Application No: WA/32/21/PL

Site Address: Land at West Walberton Lane Walberton BN18 0QF

Description of works: Construction of 30 No. dwellings together with associated access, parking, public open space & landscaping. This site may affect the setting of listed buildings, affects the character & appearance of the Walberton Green Conservation Area, is a Departure from the Development Plan & is in CIL Zone 3 & is CIL Liable as new dwellings.

Thank you for your internet representation made on 16th May 2021 which has been recorded as an objection with the comments as follows:

House Type 3BH3

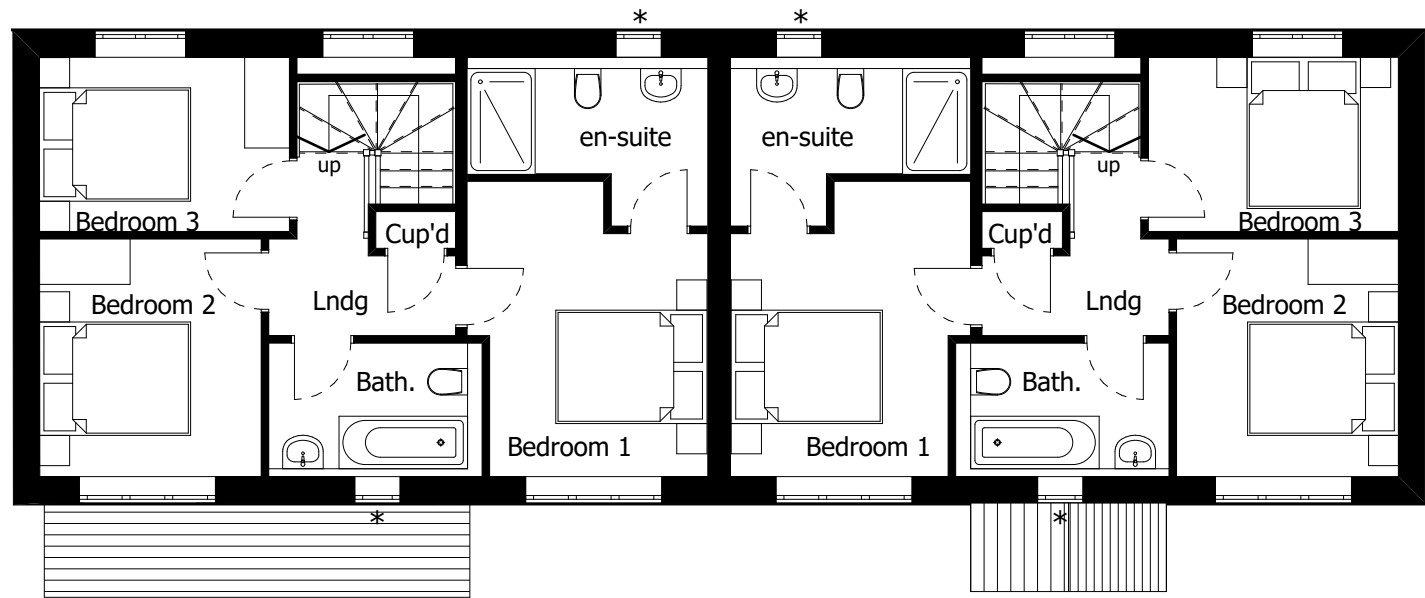
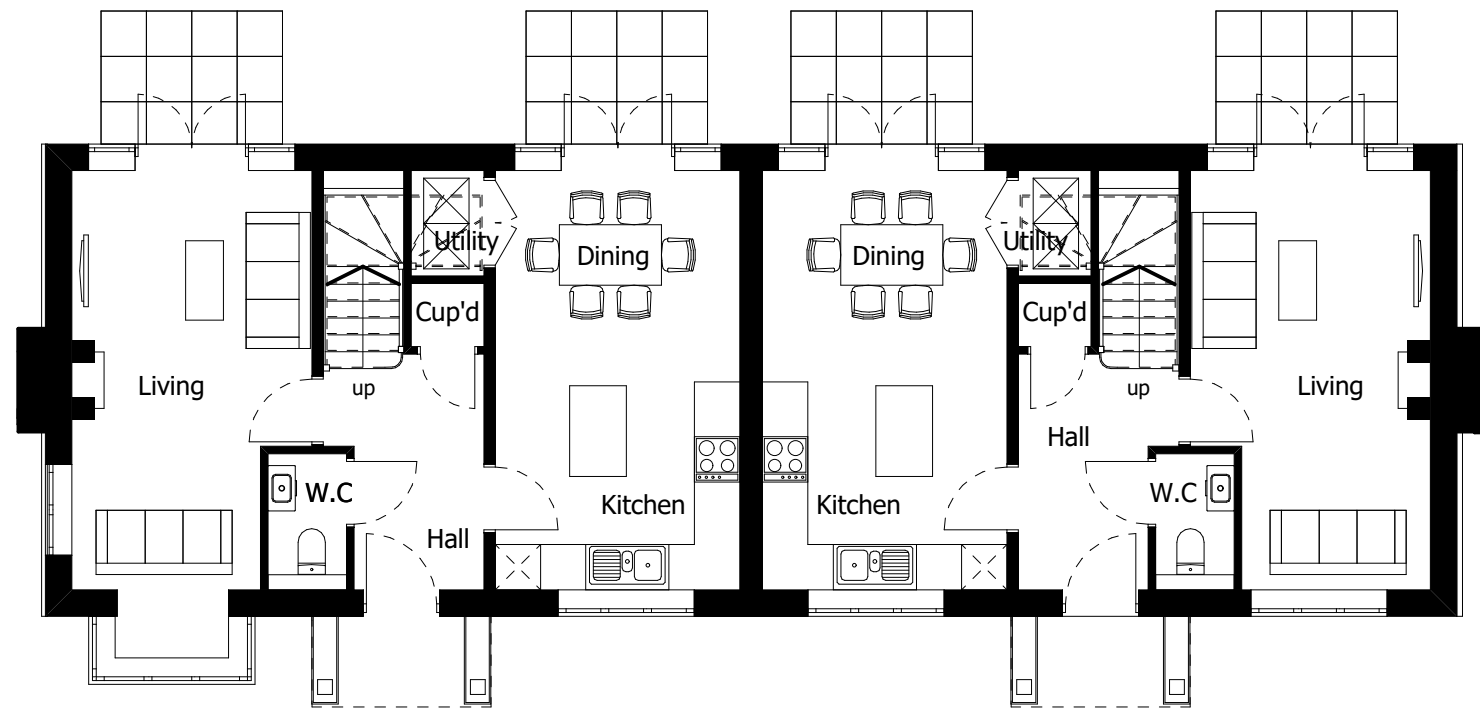
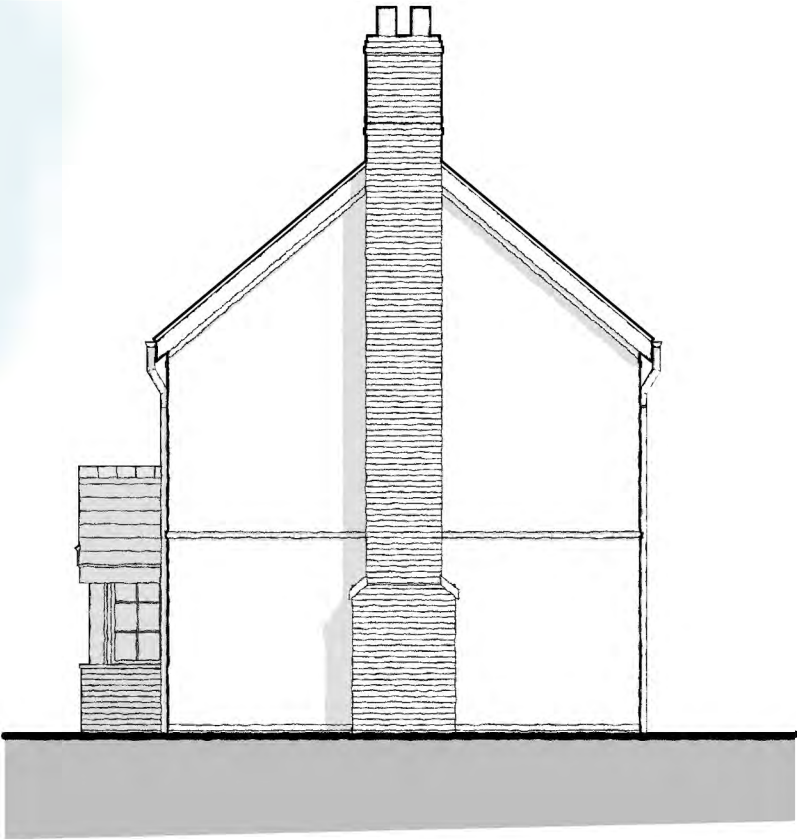
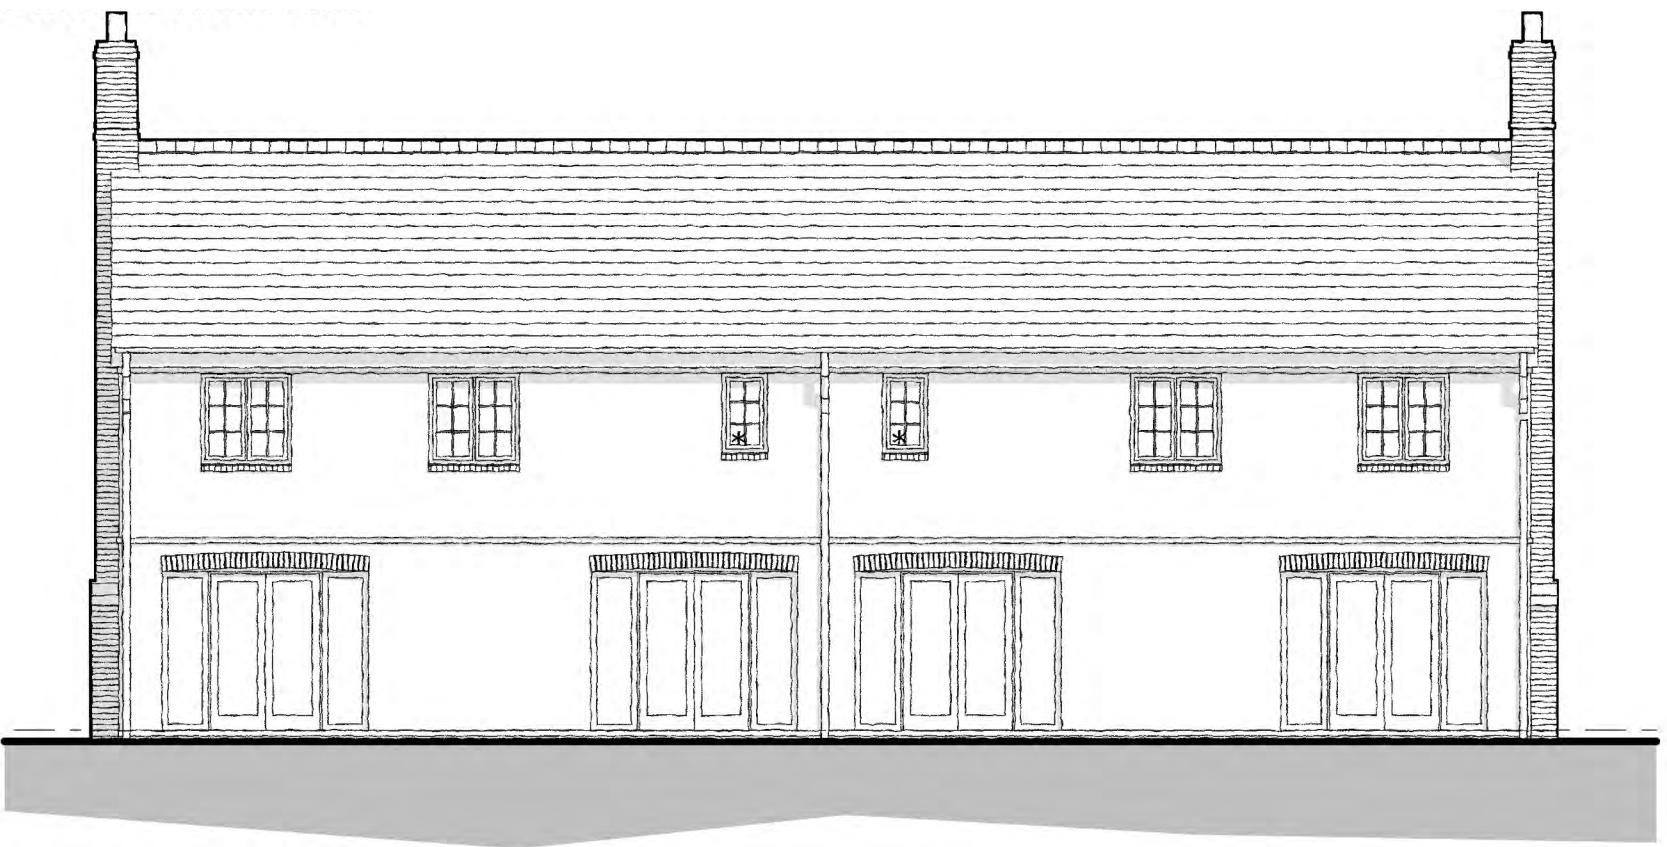
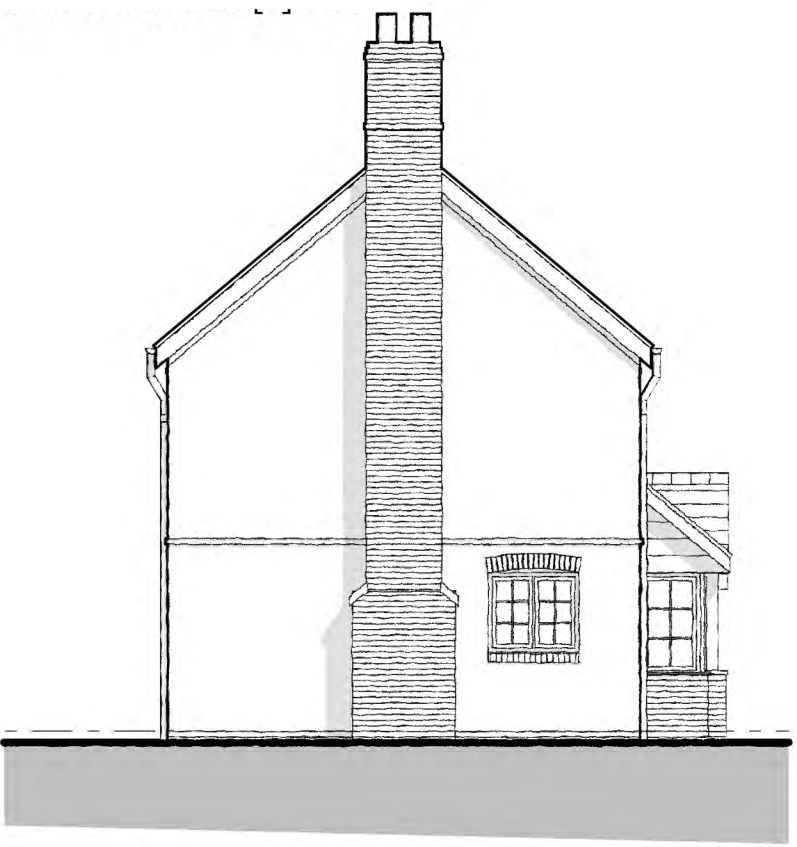
Without any prejudice to the comments made above if, for some reason, the Council is minded to grant planning permission then the Panel would strongly recommend that given the sensitive location a very high standard of materials, details and finishes be insisted upon, including hand-made plain clay tiles, natural slate and good quality stock bricks.

PROJECT
Proposed Development, West Walberton
Lane/Eastergate Lane, Walberton
CLIENT
Macra
STATUS
FOR PLANNING
DRAWING
Proposed Site Sections

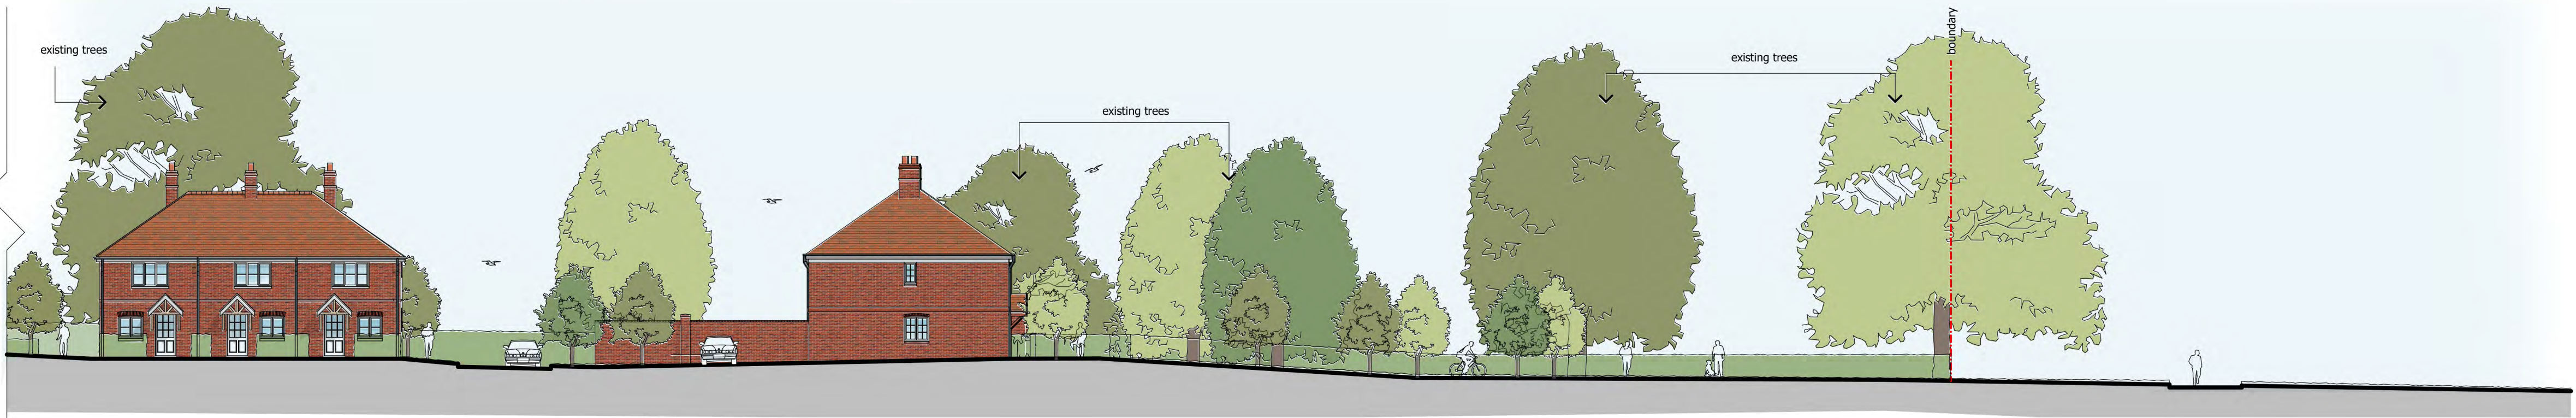
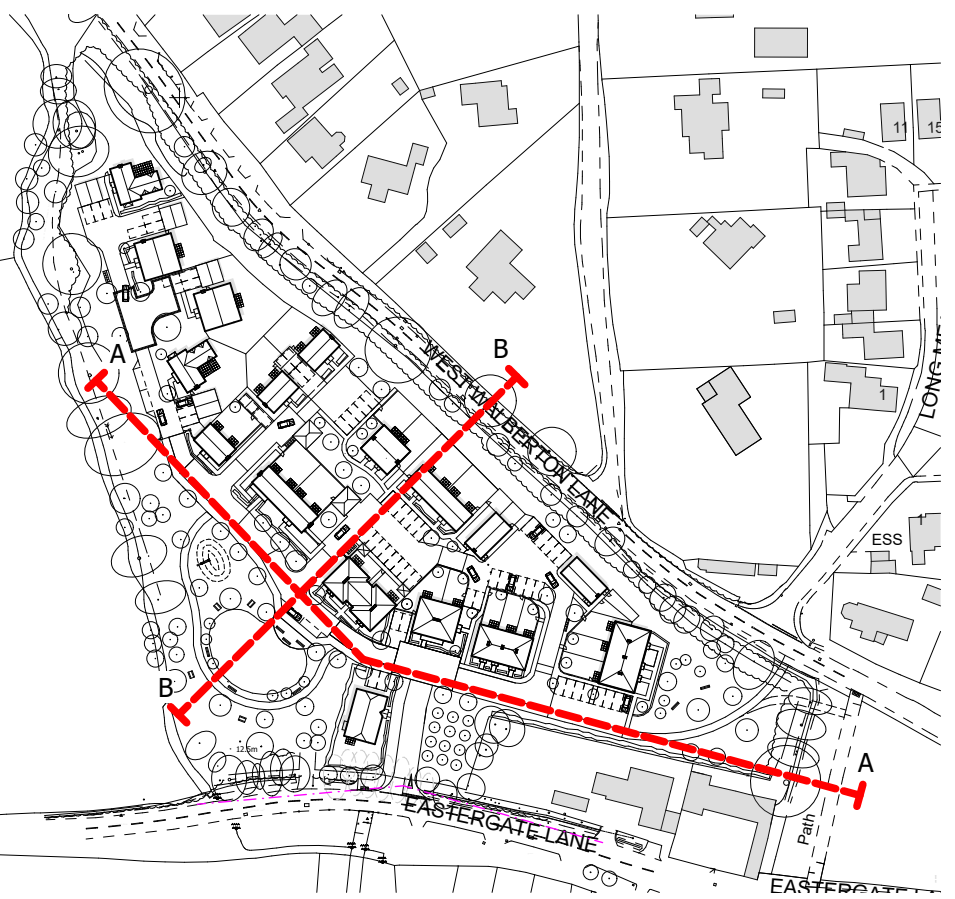
Although there is development on the north side of West Walberton Lane the approach has a distinctly rural character. If development were to take place on the south side of the road as well then that character would become suburban in nature. This would compromise the rural approach into, and adversely affect the setting of, the Walberton Green Conservation Area. Similar factors also apply to the Eastergate Lane approach to the conservation area.

It is appreciated that some thought has been given to the layout, landscape feature retention and to the designs of the proposed new dwellings so that the scheme is potentially less intrusive than a higher density scheme would be, but the presence of dwellings and other structures could never be totally concealed from view from the roads mentioned.
